Date: 8 August 2023
Ref: SI/P23-0871

Non-Material Amendment to pursuant to outline application 15/P/01611.

Builders Yard, Little London, Albury, Guildford, GU5 9DG

DRAWING TITLE HOUSE TYPE A: PLANS & ELEVATIONS
DRAWING NO. HTA-PD-100
REVISION P4

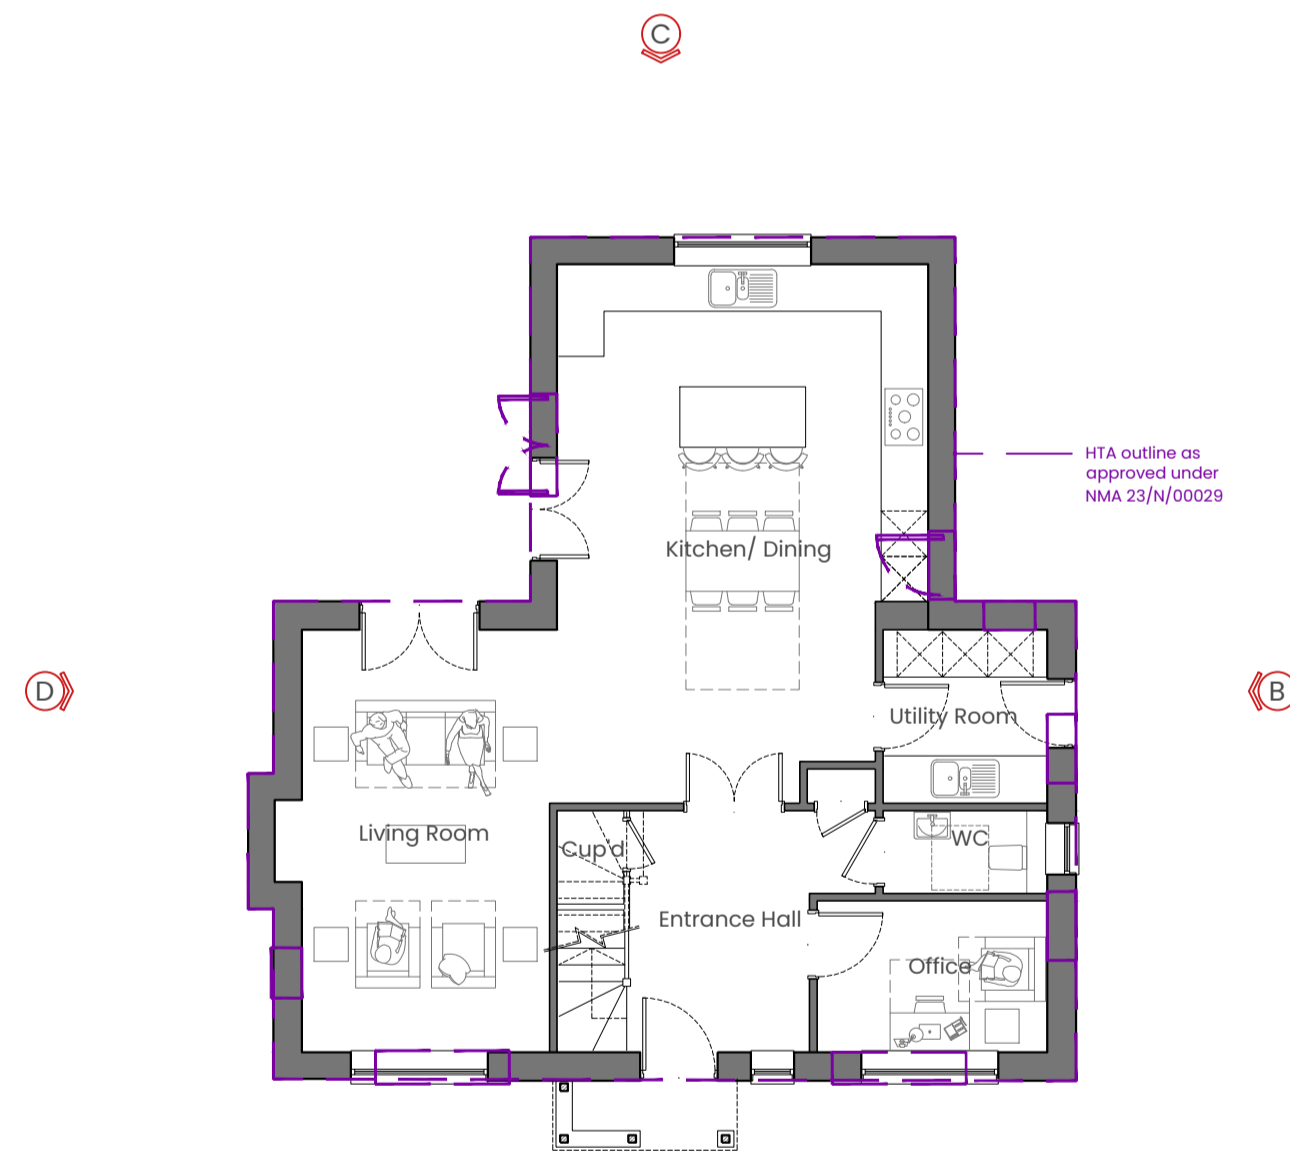
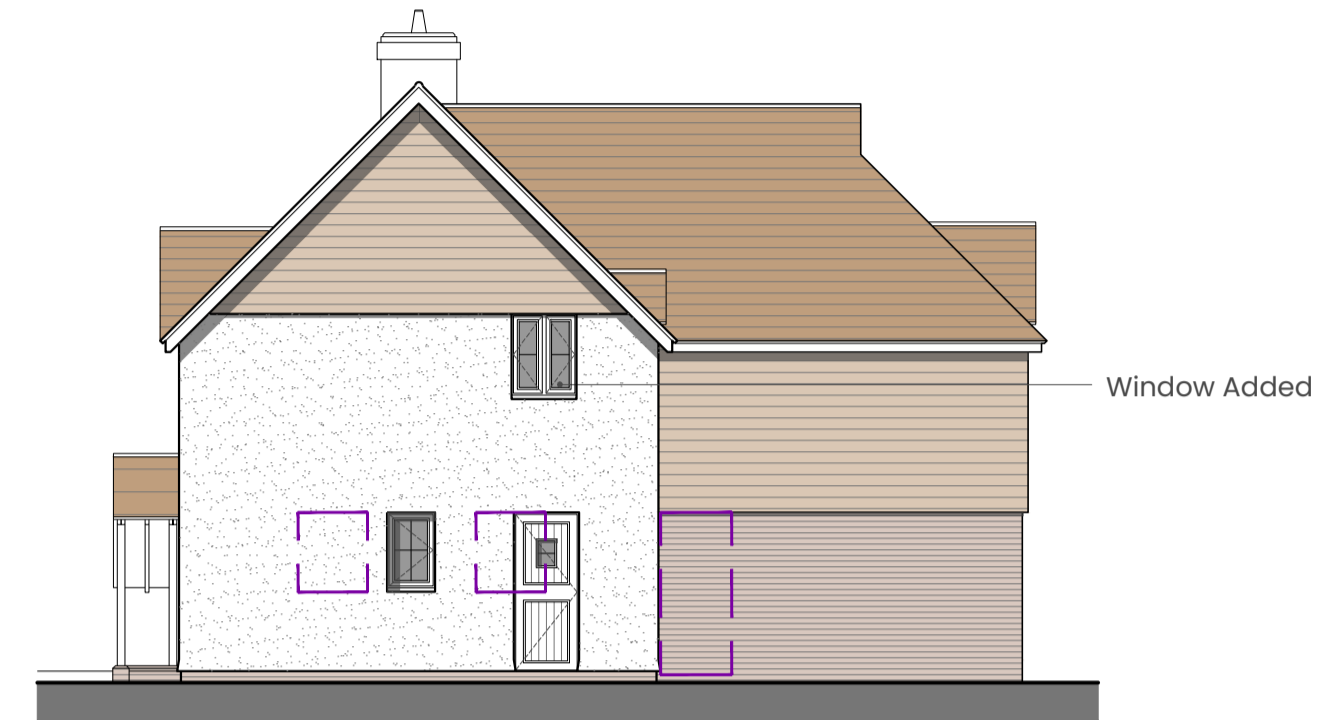
Realignment and re-sizing of windows and doors within elevations of housetype A (HTA) and housetype B (HTA). Approved under application 23/N/00029.

Alteration to building footprint of HTA and HTB. Approved under application 23/N/00029.

HTA footprint approved at outline (15/P/01611) – 88sqm and approved under NMA 23/N/00029 – 93.5sqm

Addition of 1st floor window to side elevation of HTA. Not yet approved to be considered within this application.

The additional window is being sought to improve the design of the bedroom within HTA and also to ensure conformity with Building Regs with regard to the fire escape strategy which the outline scheme would not comply with. There is a significant separation distance from the proposed HTA and the nearest property to the north (separate by paddock land over 20m in width) therefore additional window is considered non-material to the proposals and will have no material impact. There is also an established landscape boundary between HTA and the nearest dwelling which would restrict views out of the proposed window. A comparison between the approved outline side

Internal reconfiguration of HTA and HTB. Not yet approved to be considered within this application.

DRAWING TITLE  
**HOUSE TYPE B: PLANS & ELEVATIONS**  
DRAWING NO.  
**HTB-PD-110**  
REVISION  
**P5**

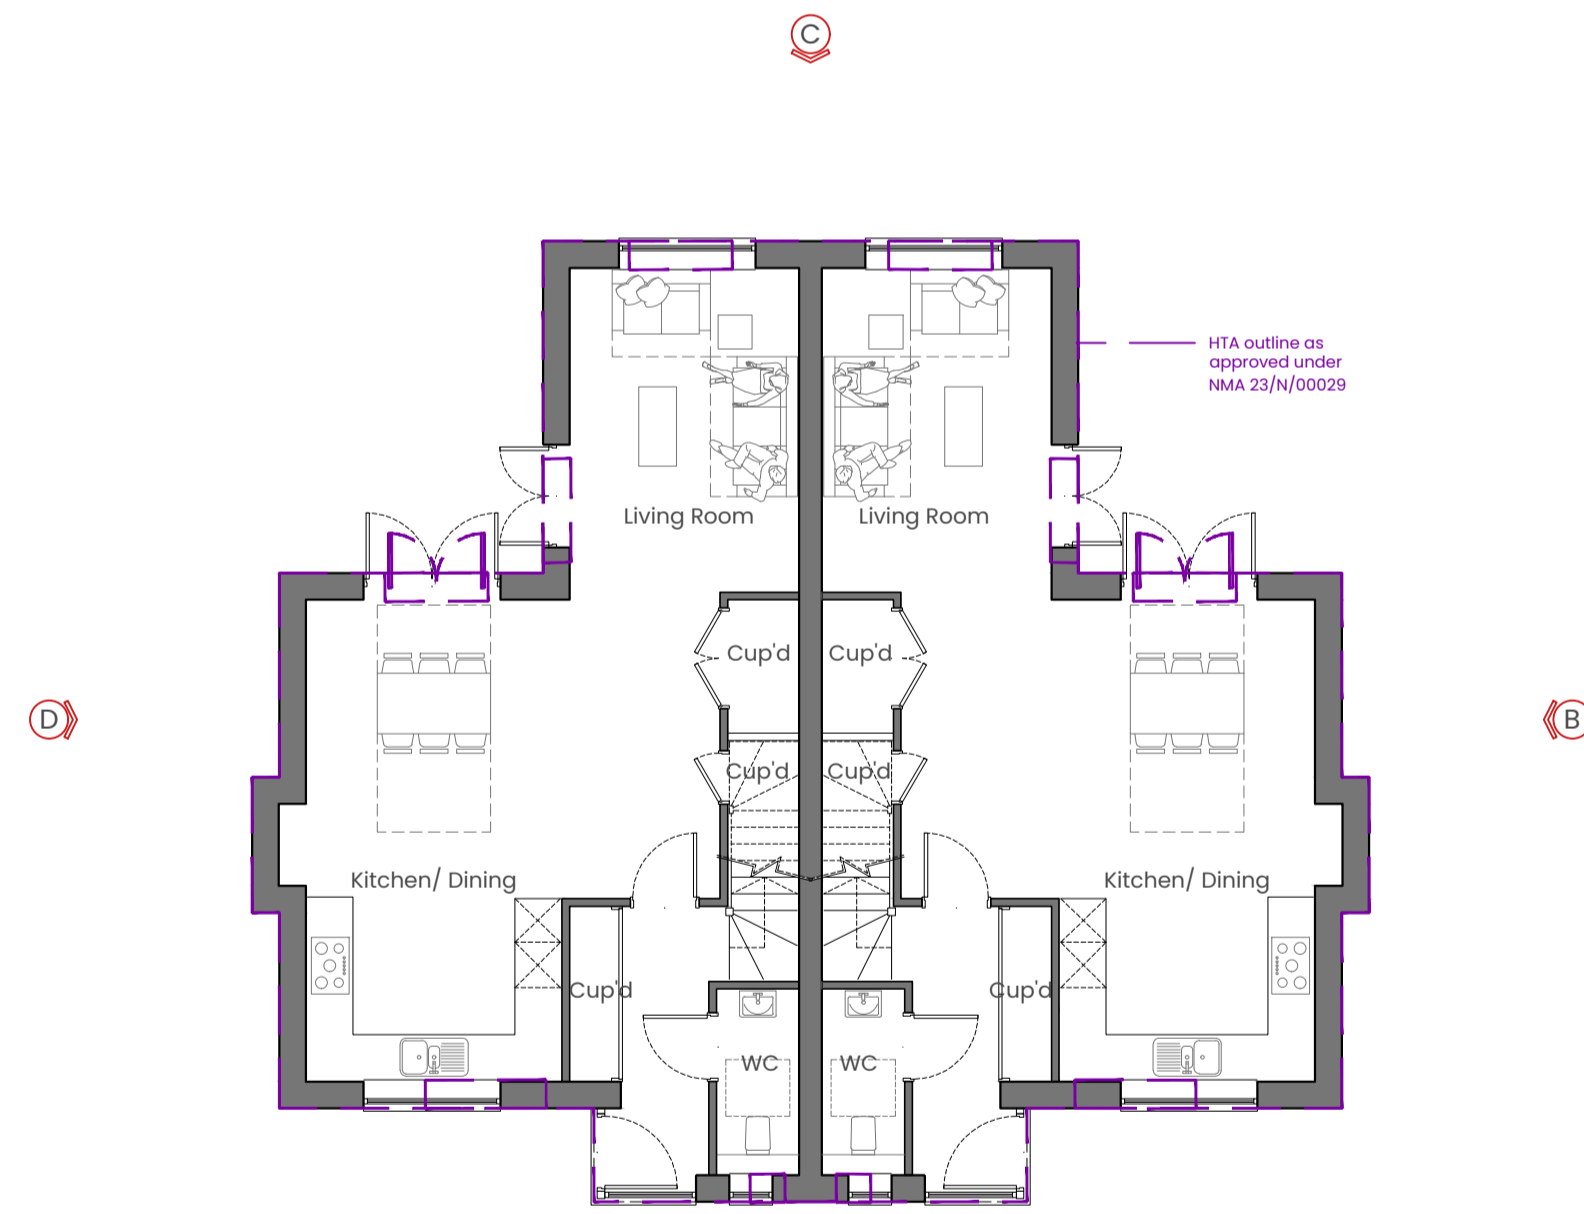
HTB (per unit) footprint approved at outline (15/P/01611) – 60.5sqm and approved under NMA 23/N/00029 – 68.5sqm
